Planning Department
Ribble Valley Borough Council
Council Offices
Church Walk
Clitheroe
BB7 2RA

Ref 2310. corr. RVBC 230808

2310 Fairfield Farm, Longsight Road, Clayton Le Dale, BB2 7JA
Application ref. 3/2023/0421

Further to our recent discussions regarding the above planning application. Below we have responded to the matters raised in your email dated 17.07.23 :-

PL.01

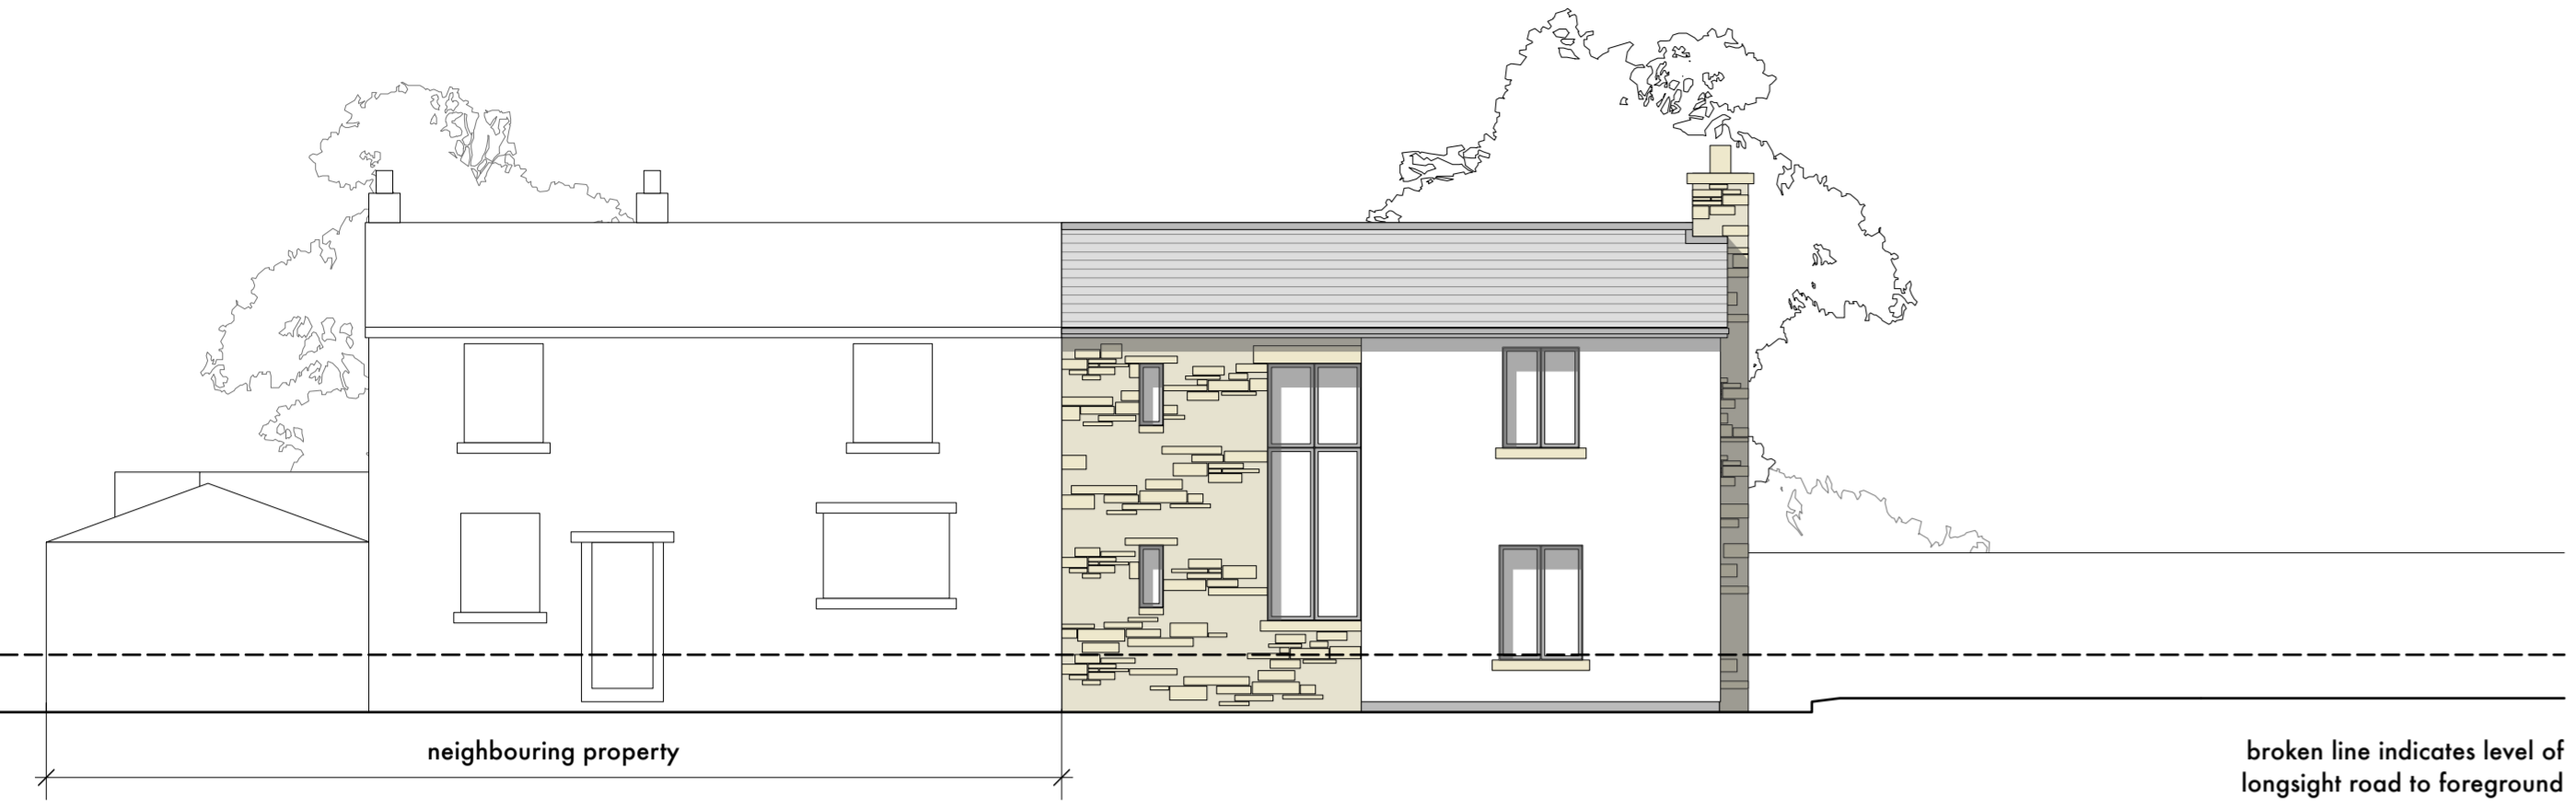
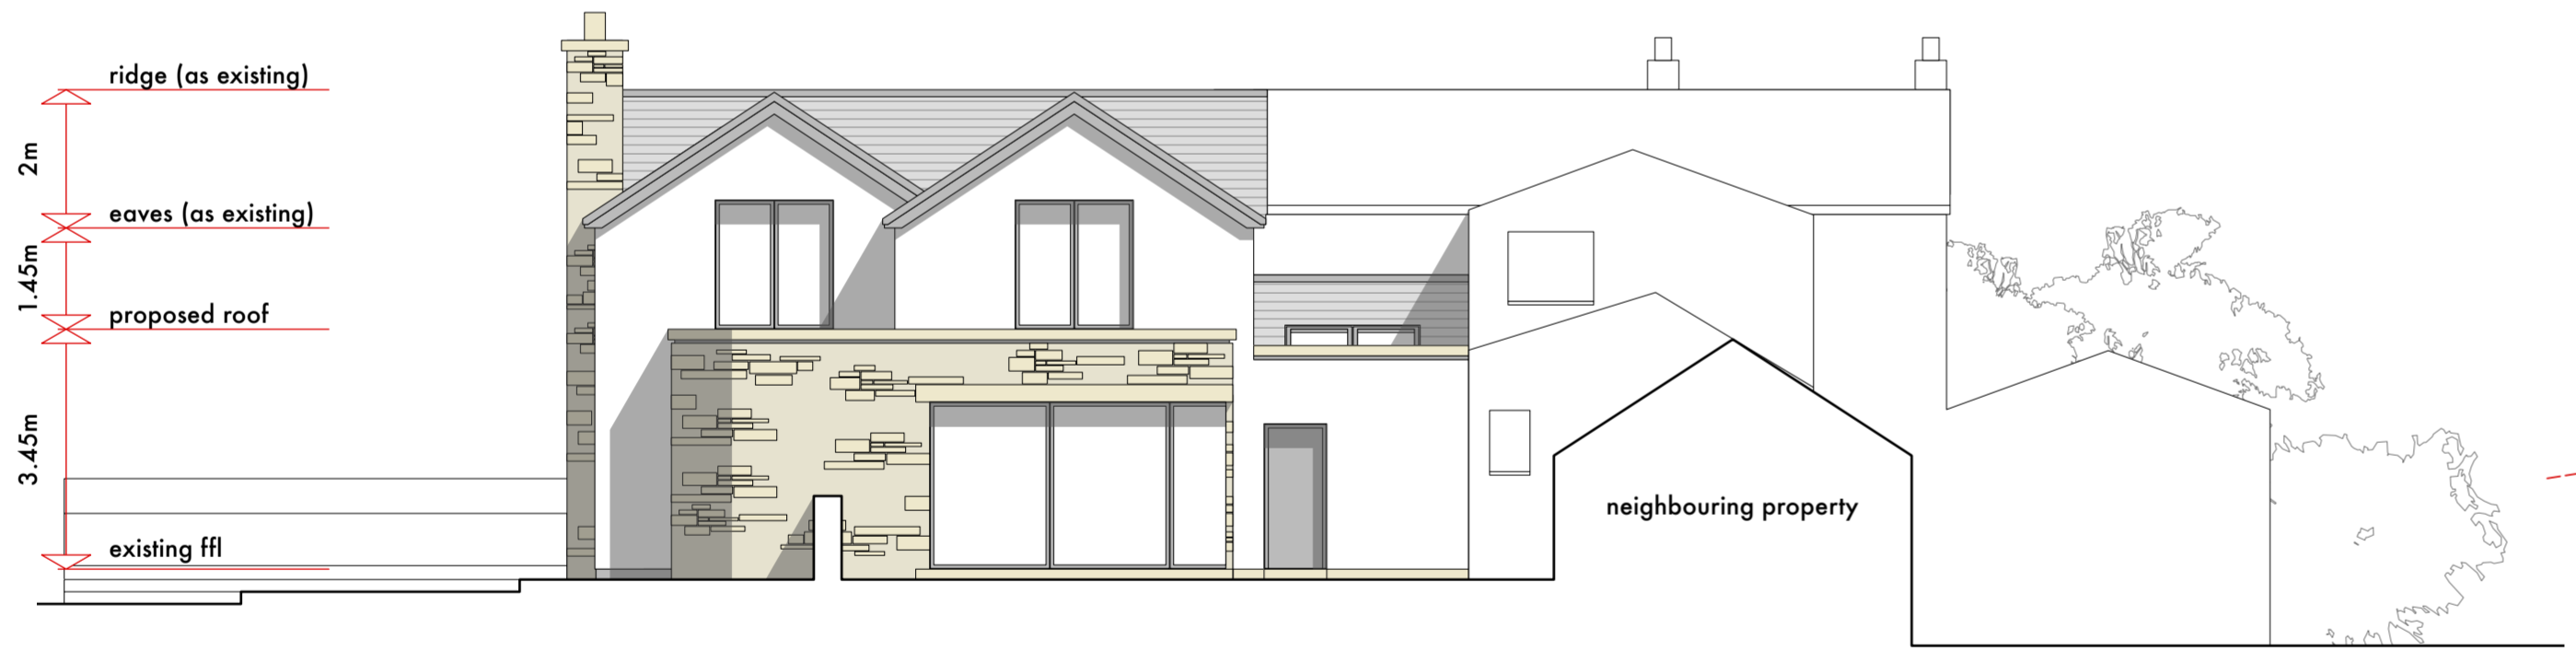
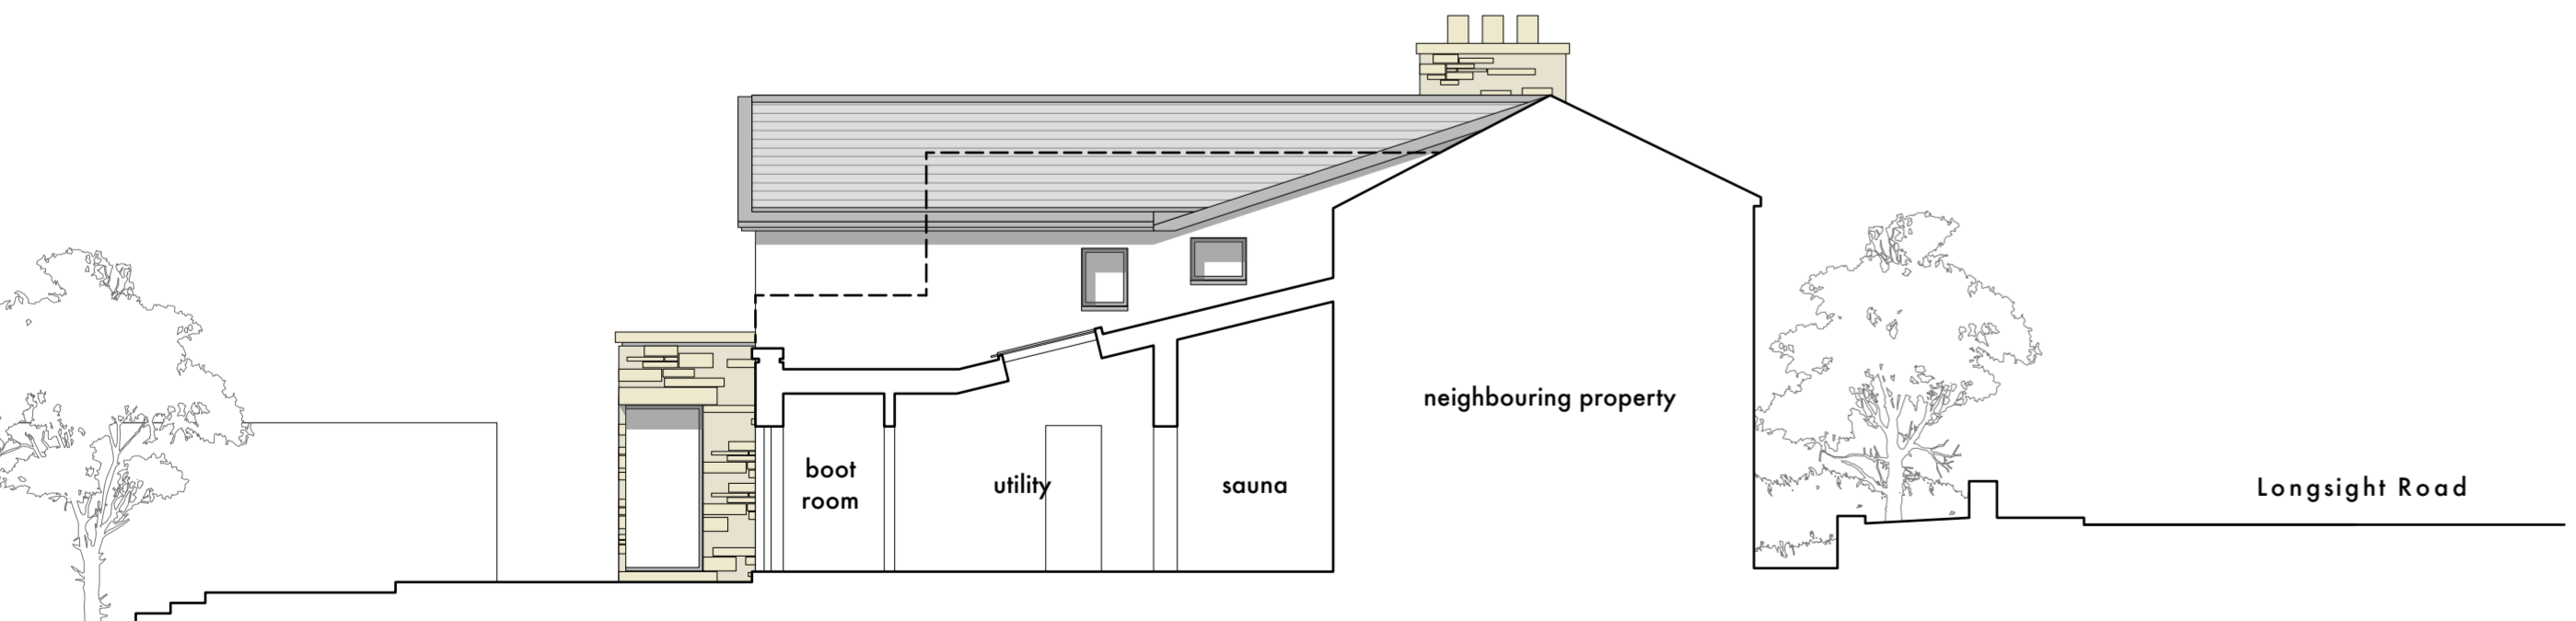
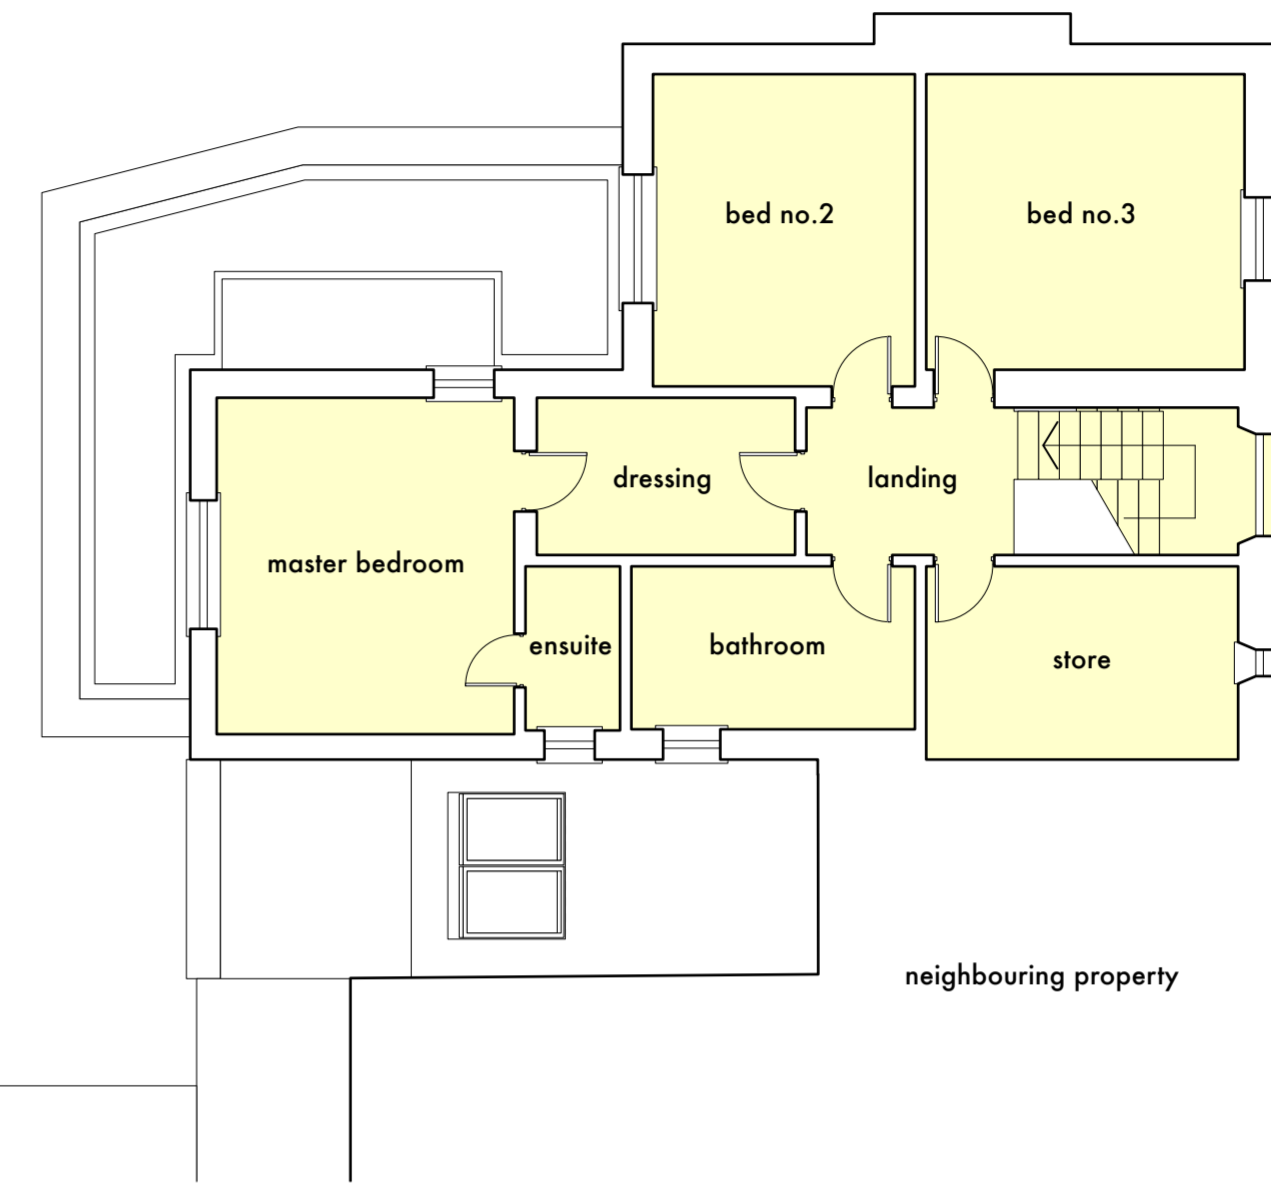
1. Chimney - The proposals aim to address the concerns raised about the width of the chimney. The width has been reduced from 2.7m to 2.1m.
2. Windows - The existing property features narrow slot windows plus horizontal and vertical format rectangular windows - this variety of windows profiles is also present in the neighbouring properties. However we acknowledge your comment, the proportion of the windows to the NE and SE elevations (facing Longsight Road) have been fully reviewed and are now more in keeping with the property and context.

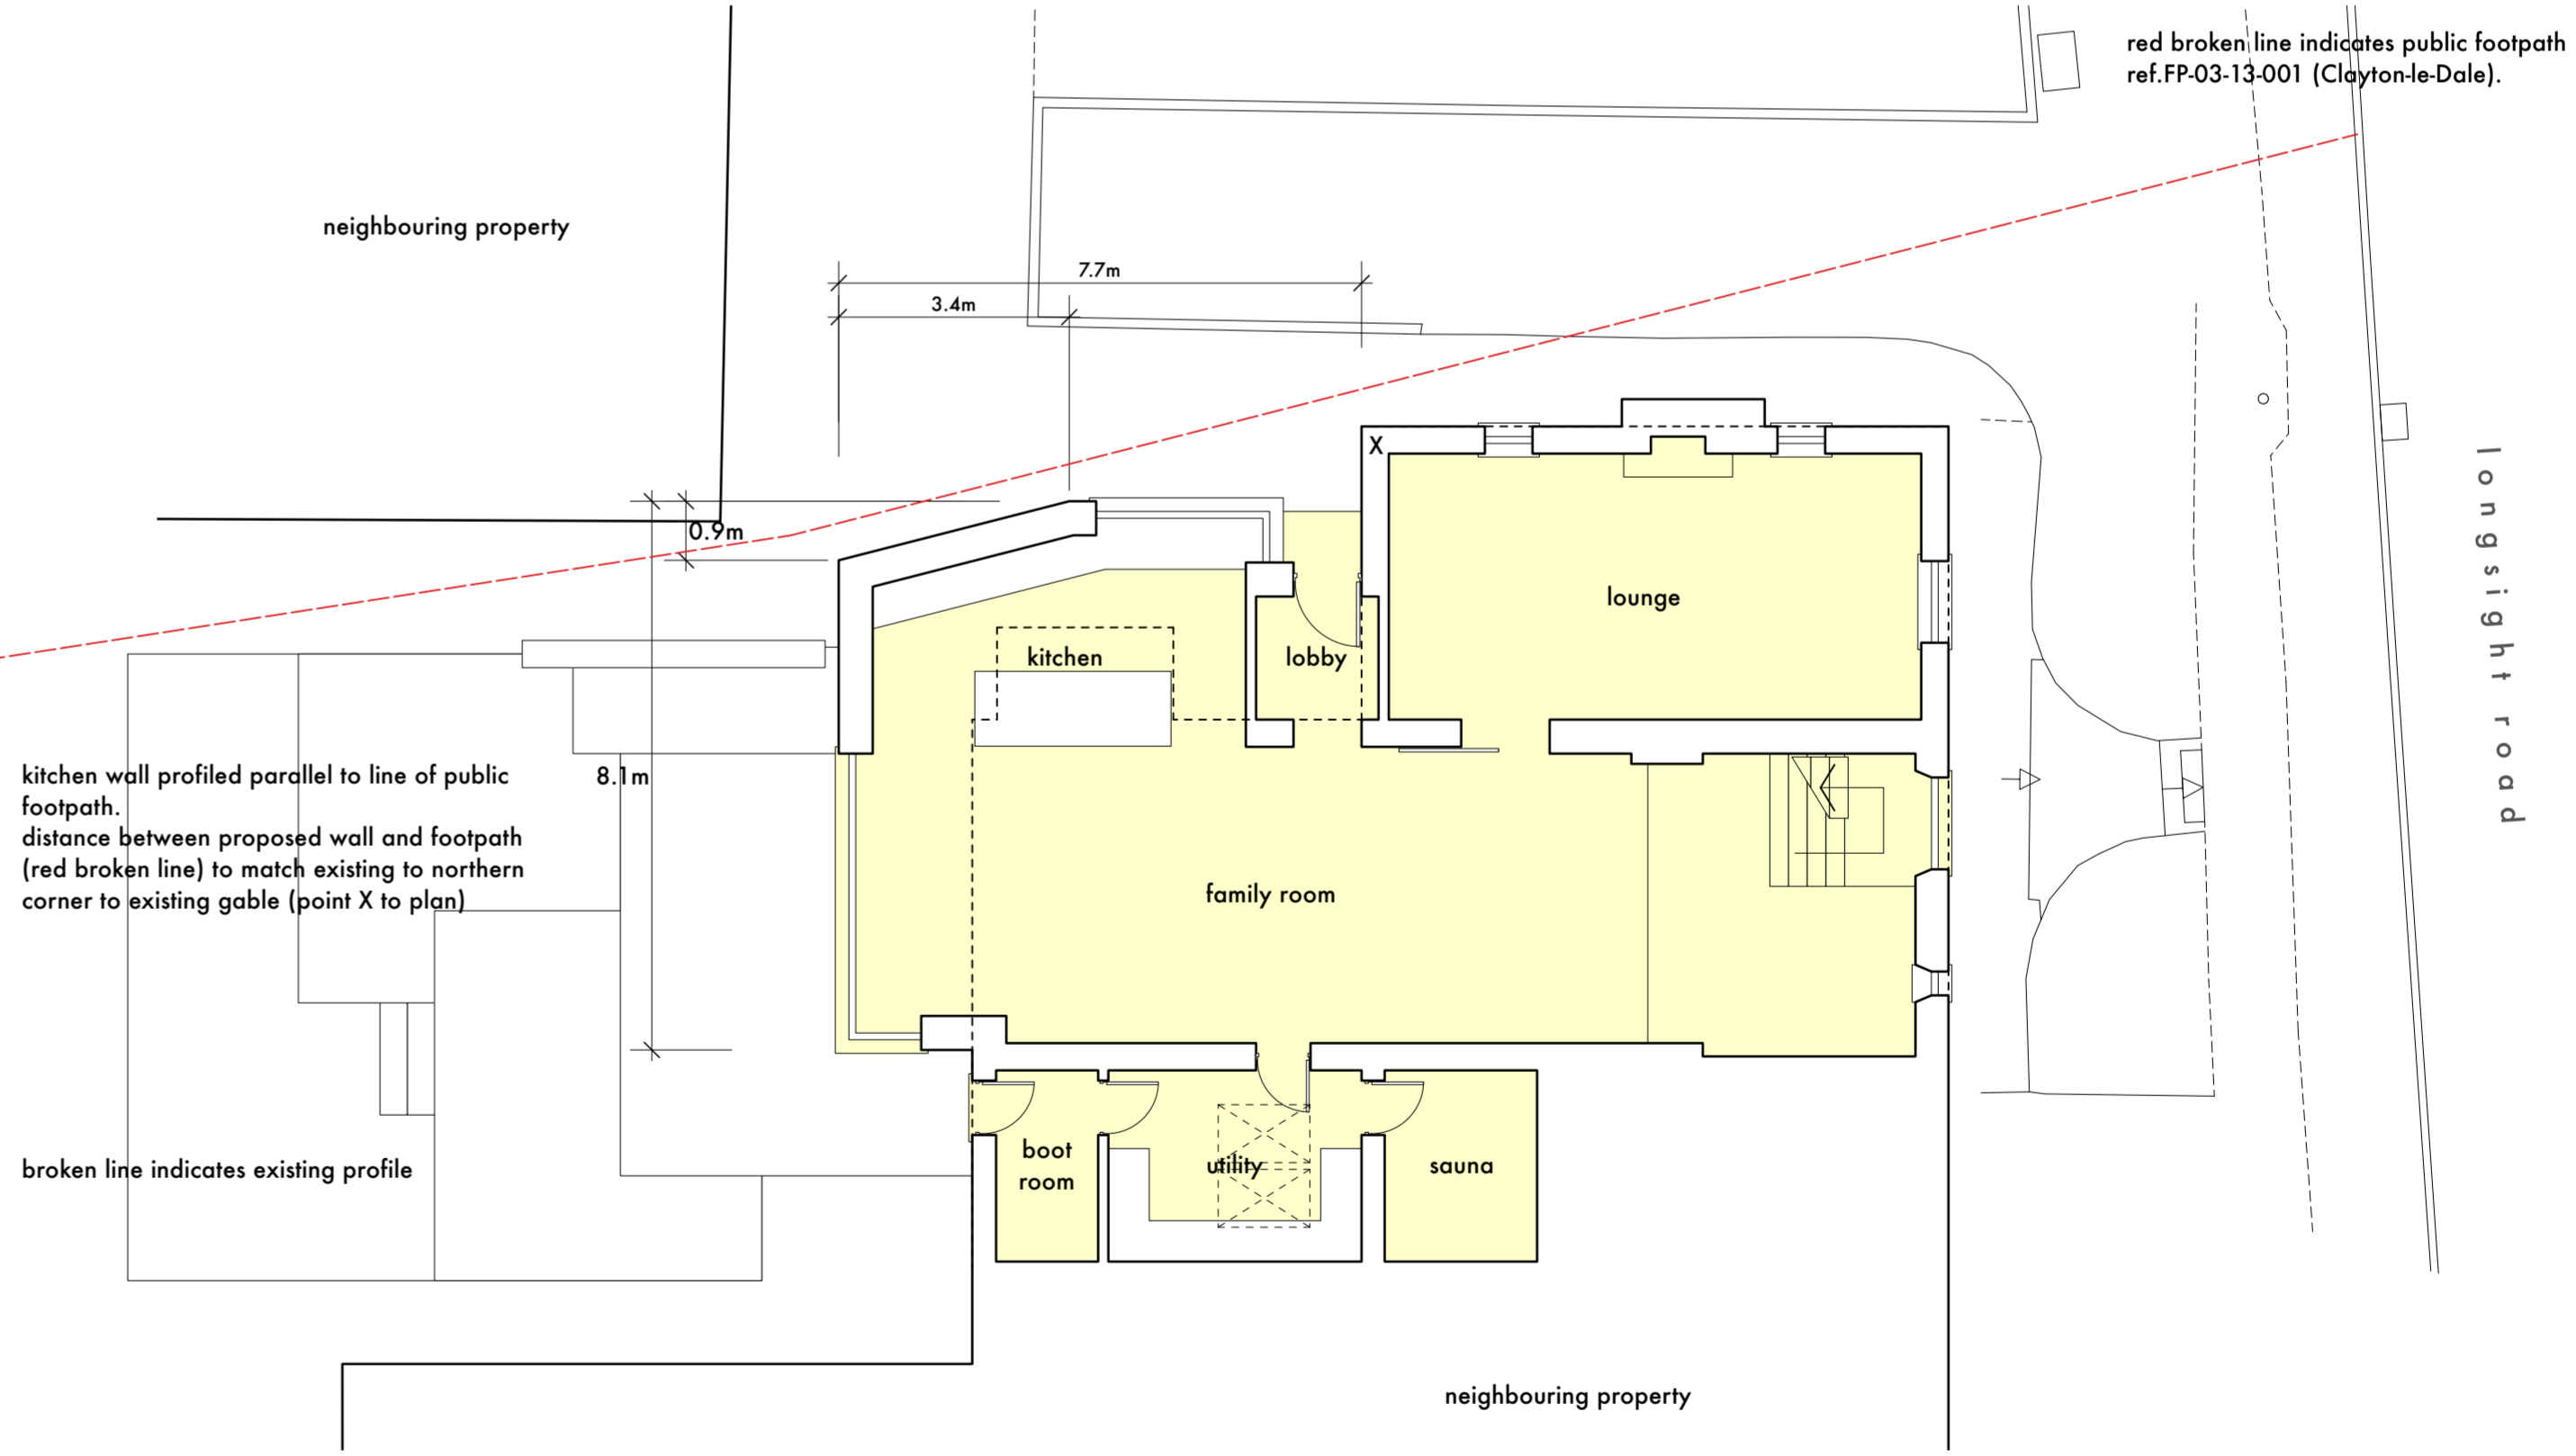
3. Public Right of Way - Thank you for forwarding details of the Public Right of Way (FP-03-13-001, Clayton-le-Dale) - this has now been accurately included on our plans. The profile of the proposed extension has been adjusted to accommodate the footpath, providing and maintaining the current clearance between the footpath and the existing property. The garden to the NE will also be unchanged from its existing arrangement.
